Recommendation Report for Planning Permission for Works or Extension to a Dwelling

REF NO: FG/121/20/HH

LOCATION: 10 South Drive
Ferring
BN12 5QU

PROPOSAL: Proposed front and rear extensions, to include raising the ridge height of the existing bungalow to create a new first floor level and proposed swimming pool.

Job Number: AR-146 Drawing Number: 02 Revision: Revision

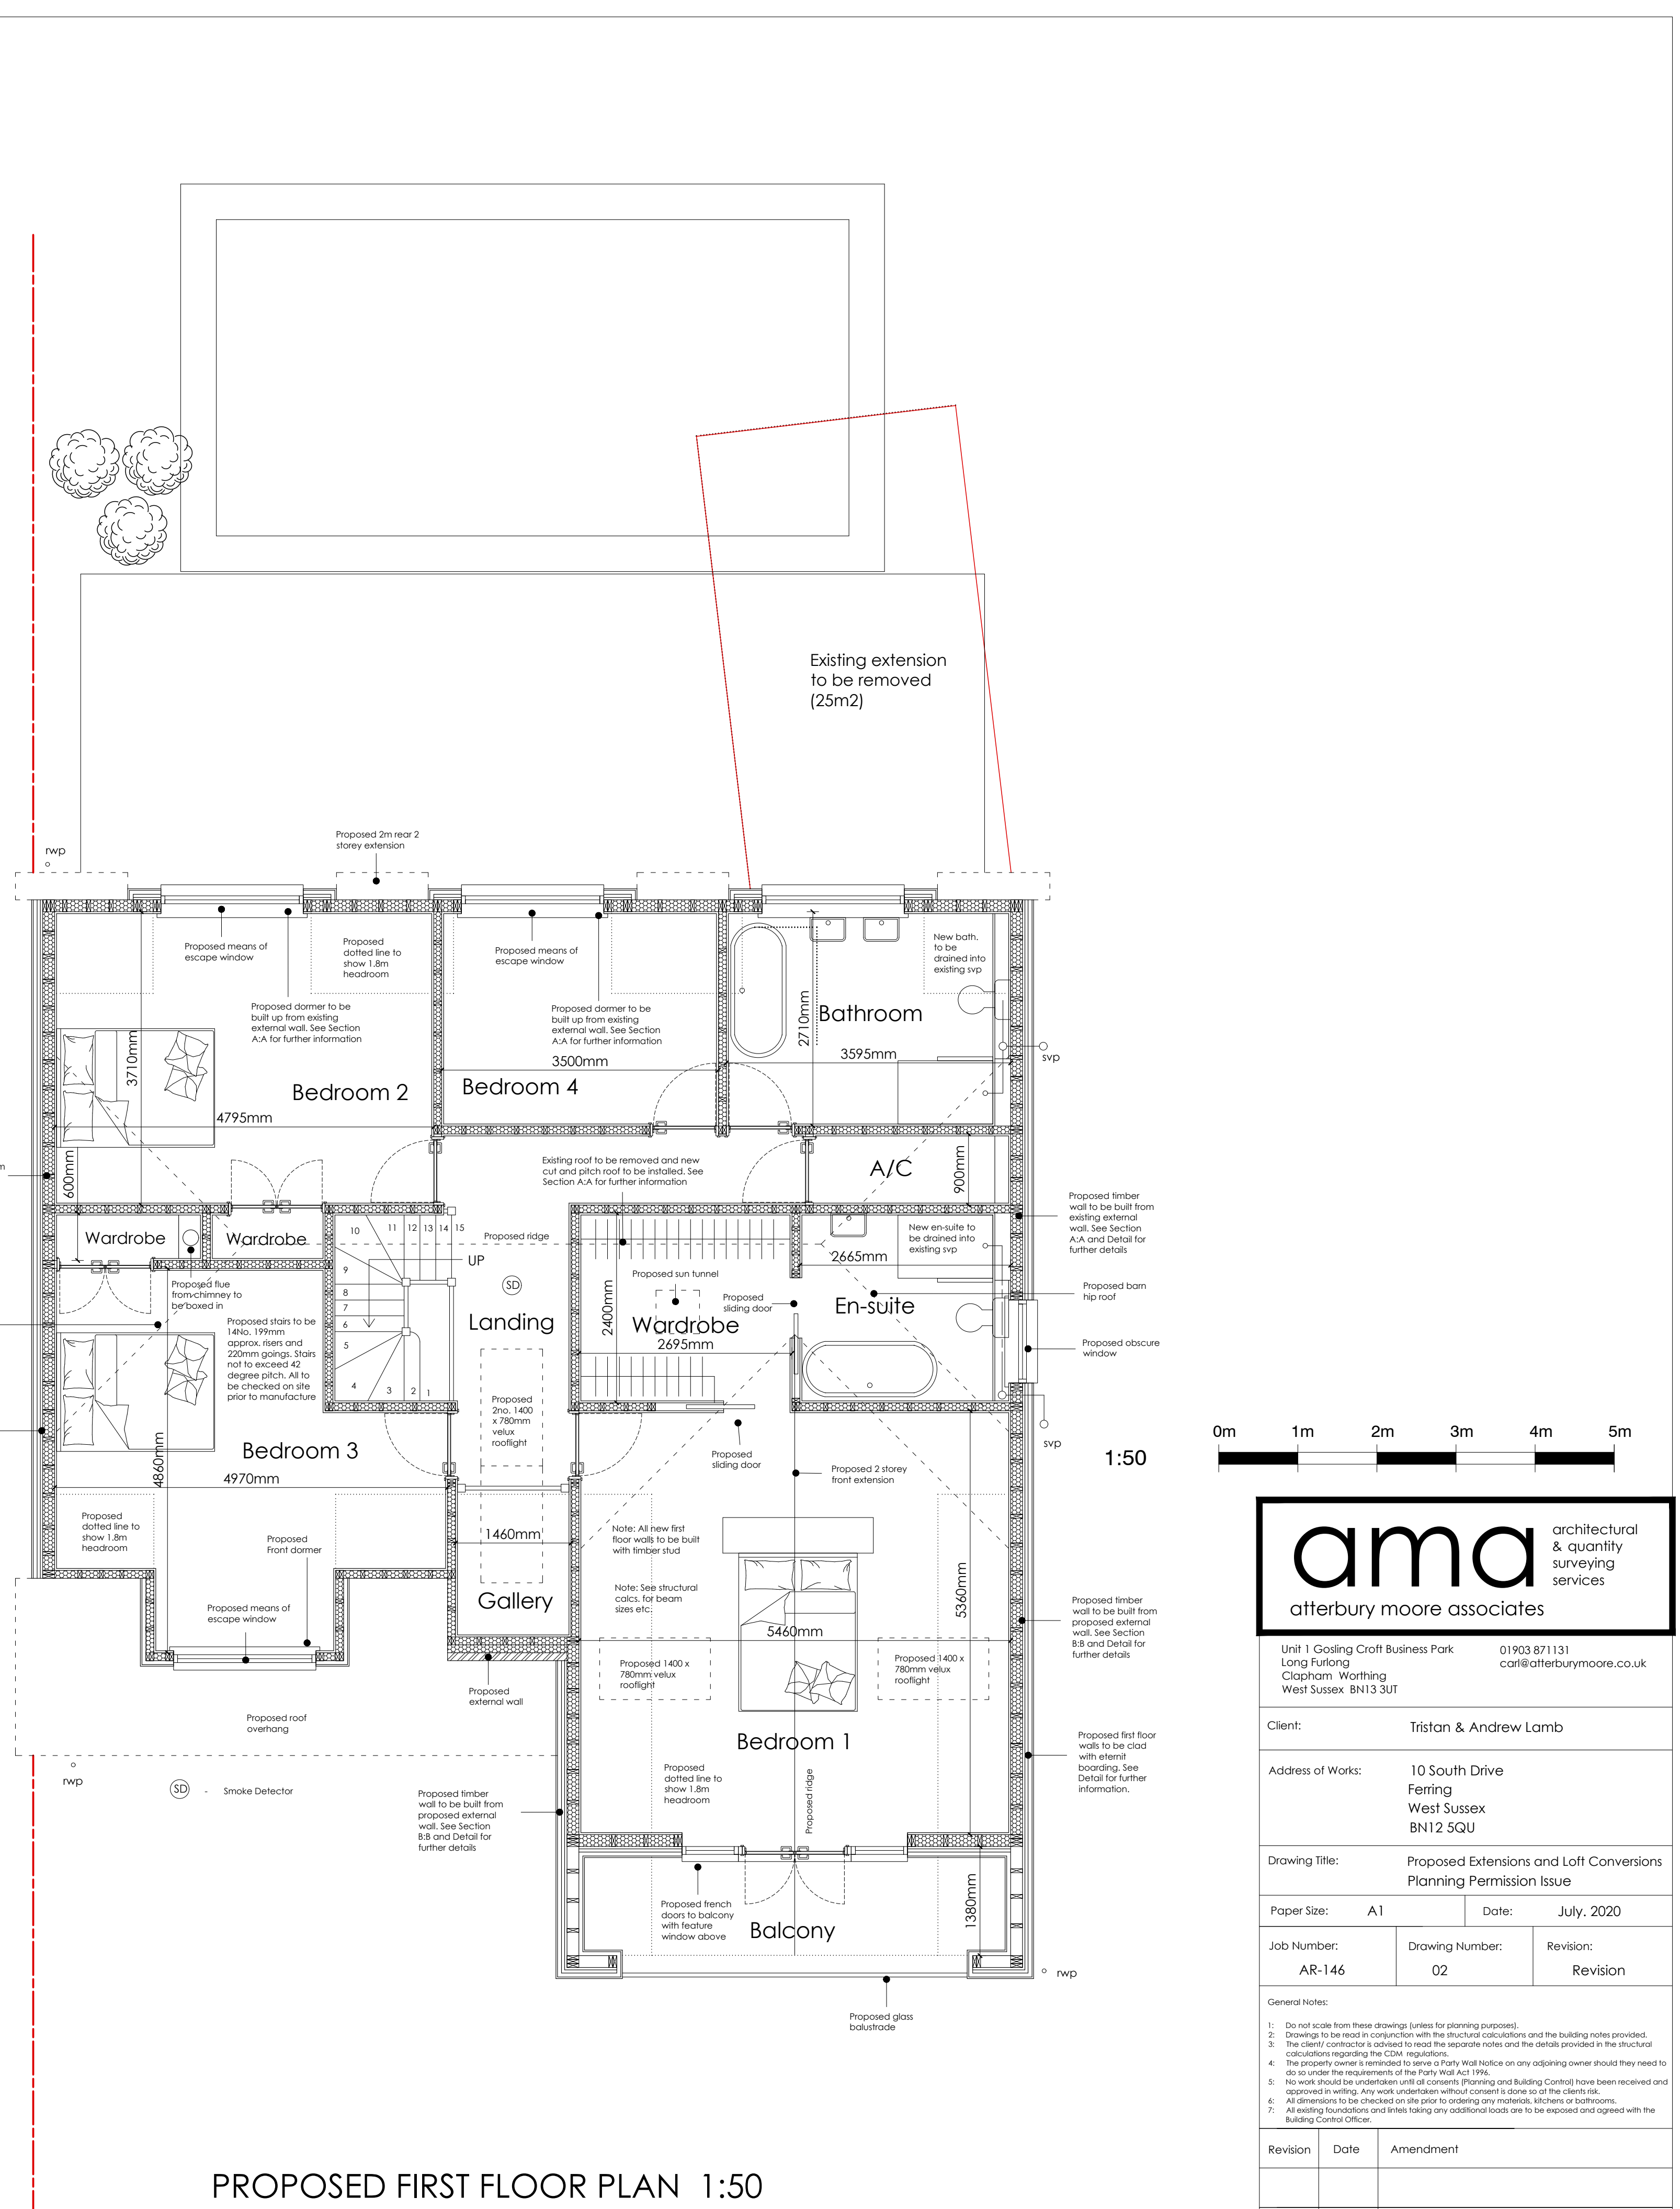
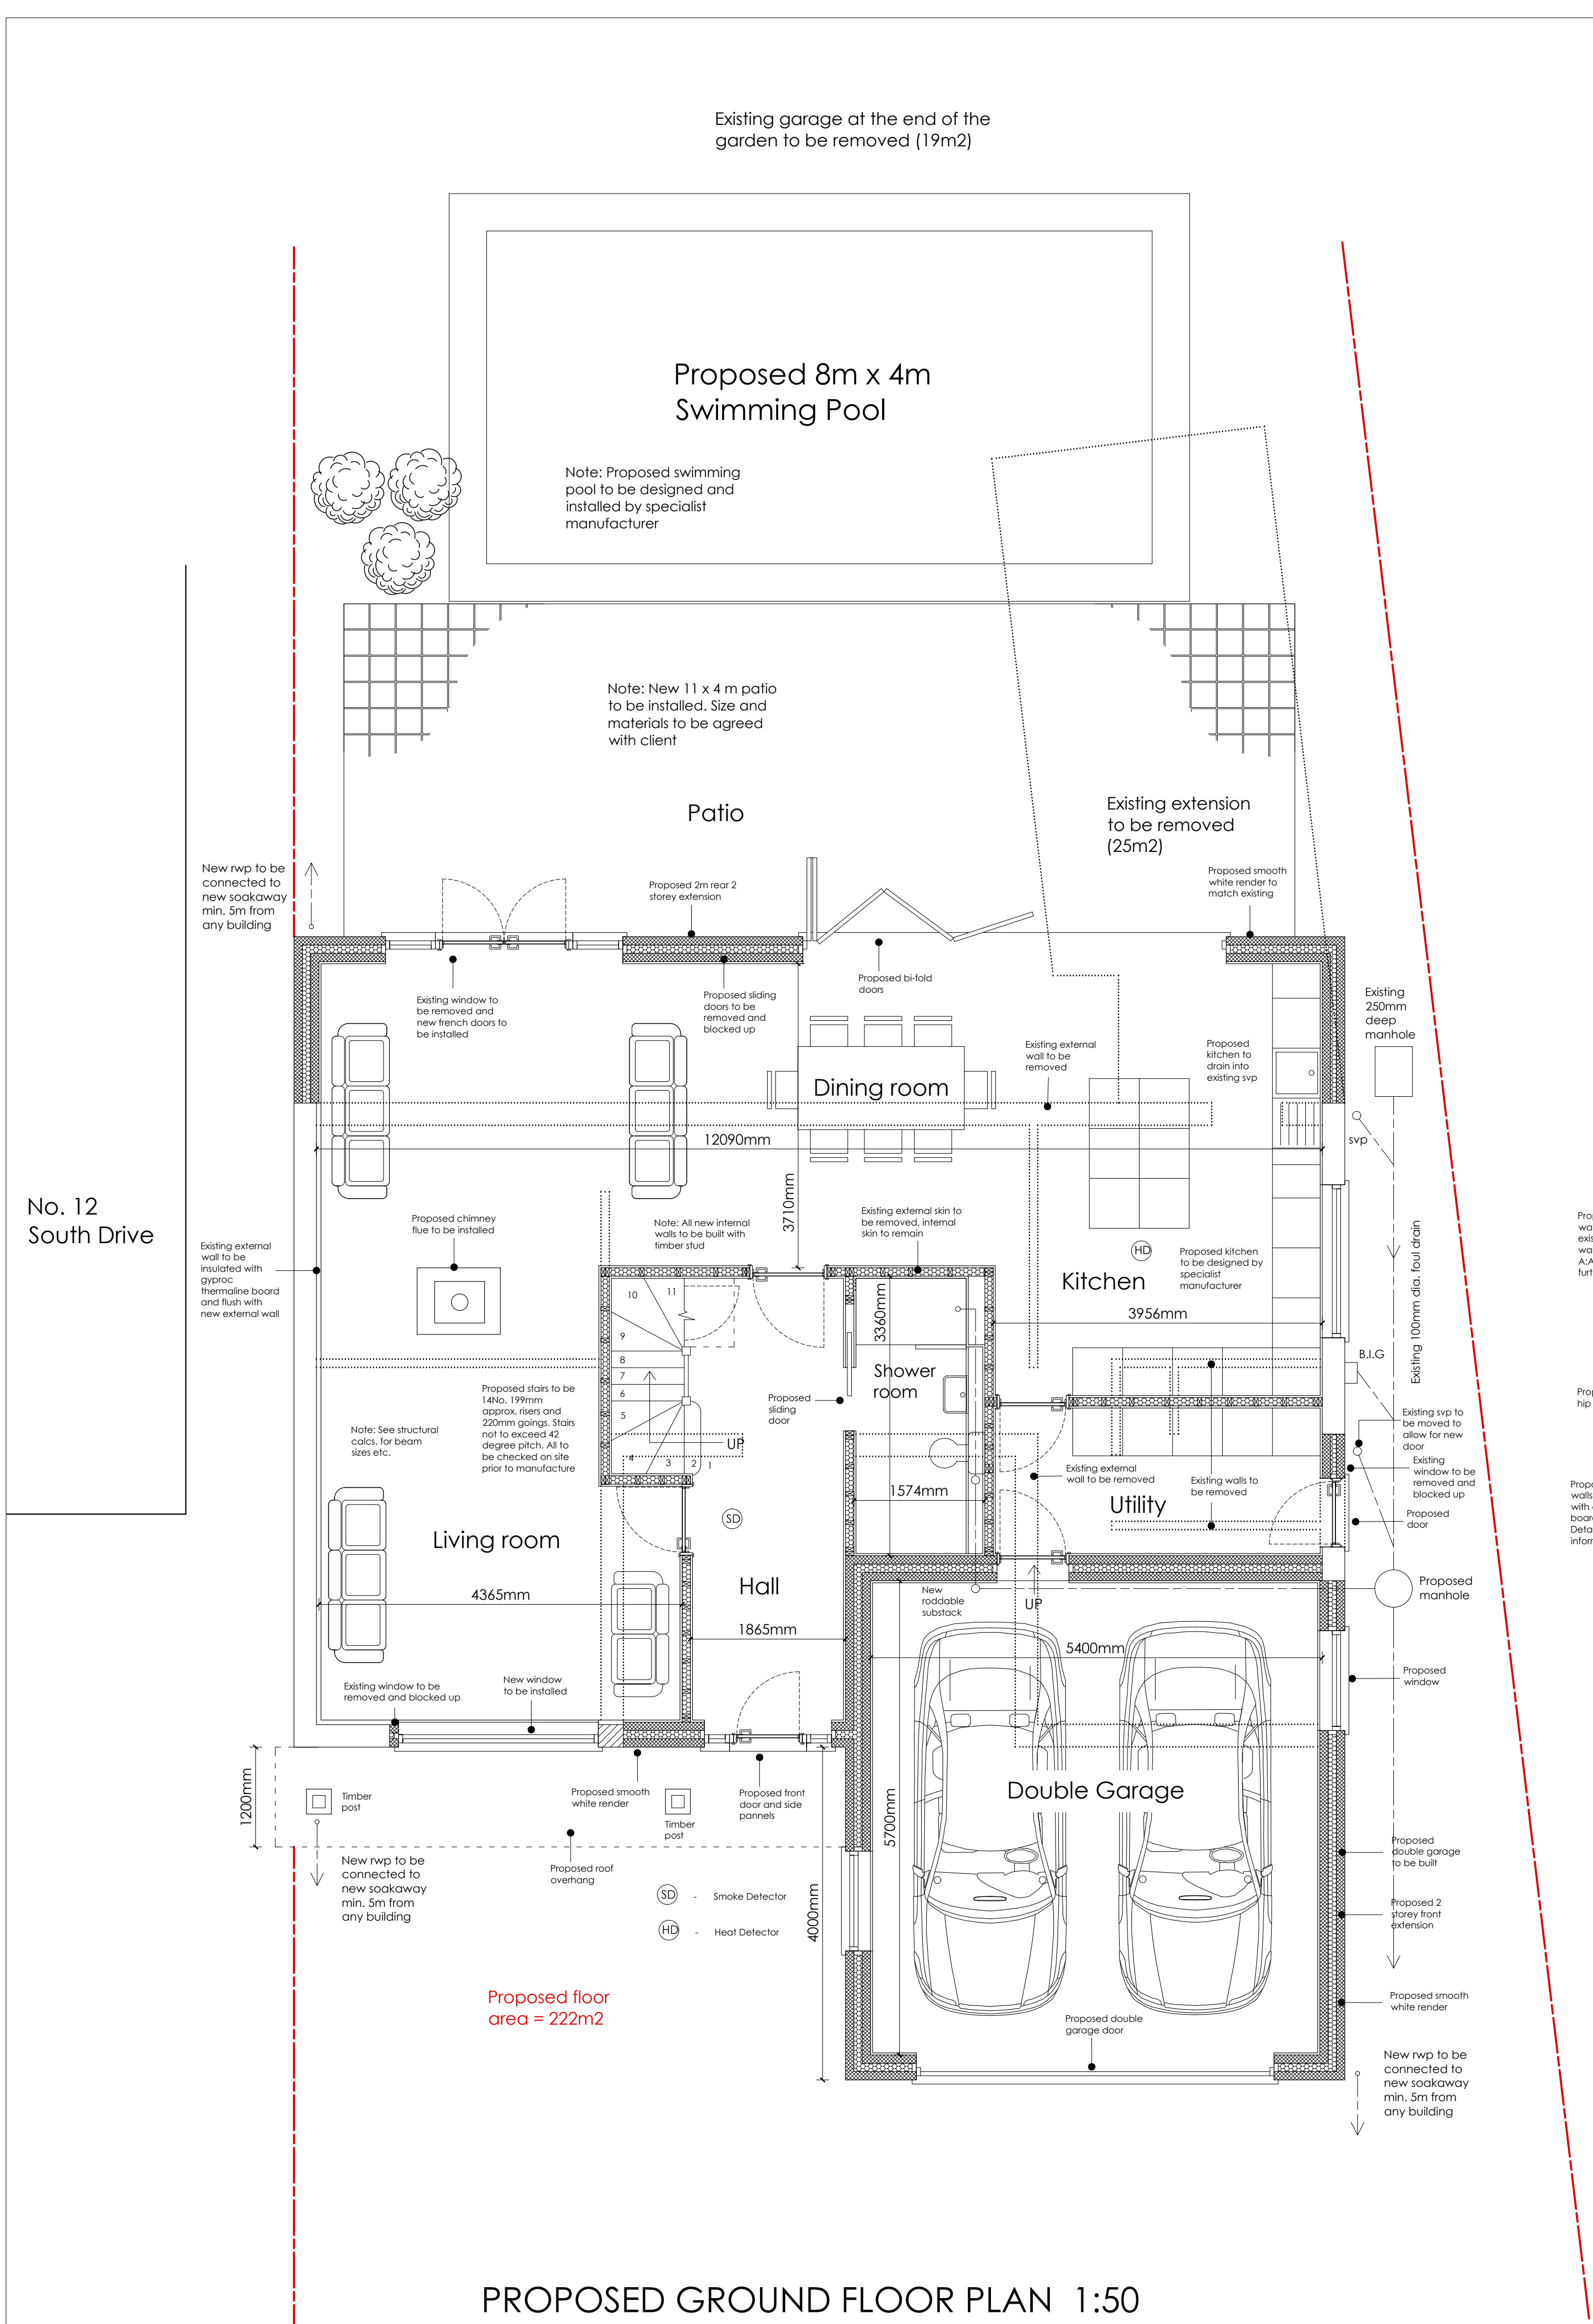
The roof would be raised from 5.04 metres to 7.74 metres in height to incorporate an entirely new first floor. The footprint of the building would be extended 1.95 metres at the rear and 4.00 metres on the east side at the front. The dwelling is proposed to be extended such that it will turn from being a single storey dwelling to a two storey property.

The building as, partly, extended would be between the building lines of neighbouring dwellings and therefore would not be considered to cause a loss of light or overbearing impact. The front extension on the east side will project out beyond the front building line with 12 South Drive however this would just be on the east side of the dwelling and sufficiently distant so as not to impact upon the neighbouring property.
